# GRADING AND EROSION CONTROL PLAN

## JUDGE ORR ROAD RV PARK AND STORAGE

### EL PASO COUNTY, COLORADO

FIGURE OS-1. TRASH RACK SIZING

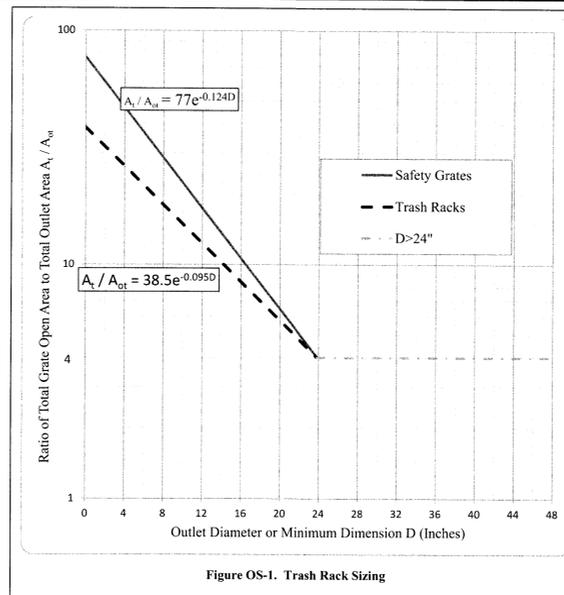
Figure OS-1 is missing. Resolved.

Review 6: Mark on the figure OS-1 the trash rack size. We anticipate two lines (horizontal/vertical) so the contractor can identify the size required.
